STRUTHERS RANCH POLARIS LOTS 1-2, STRUTHERS RANCH SUBDIVISION FILING NO. 4

SITE UTILITY PLAN

Utility Plan_v1.pdf Markup Summary

SITE UTILITY PLAN

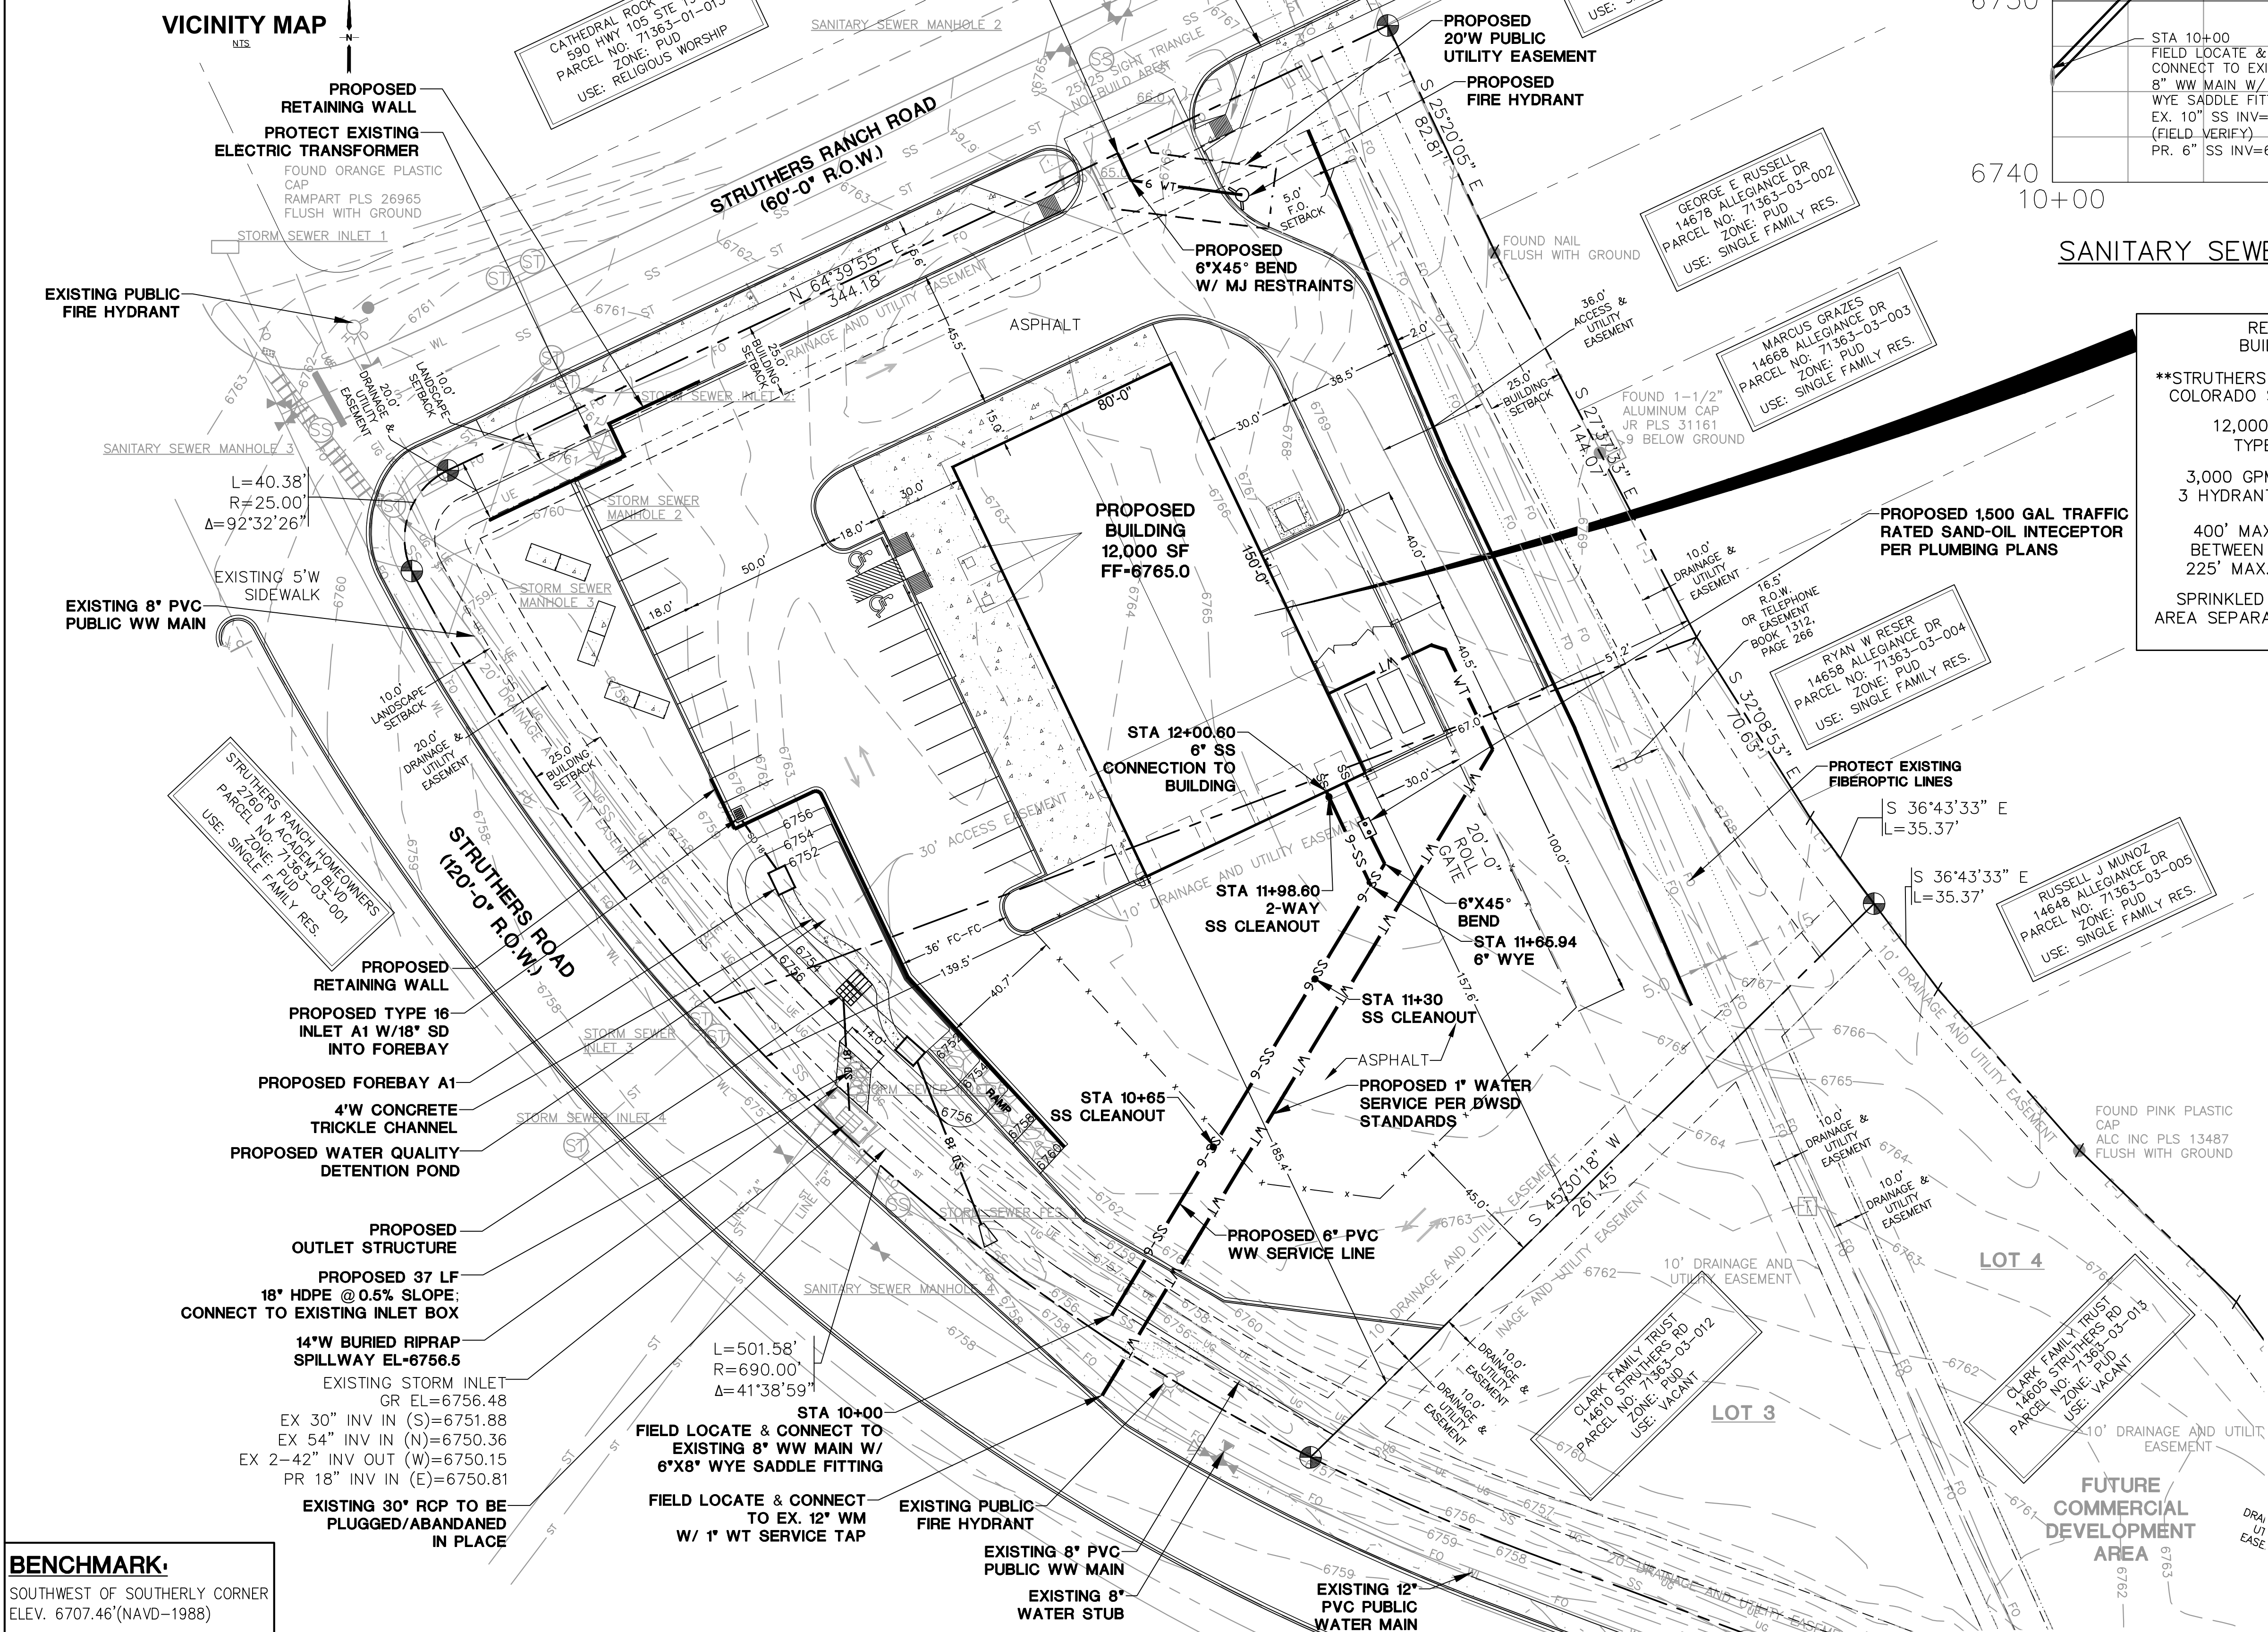
Struthers "RANCH" Rd
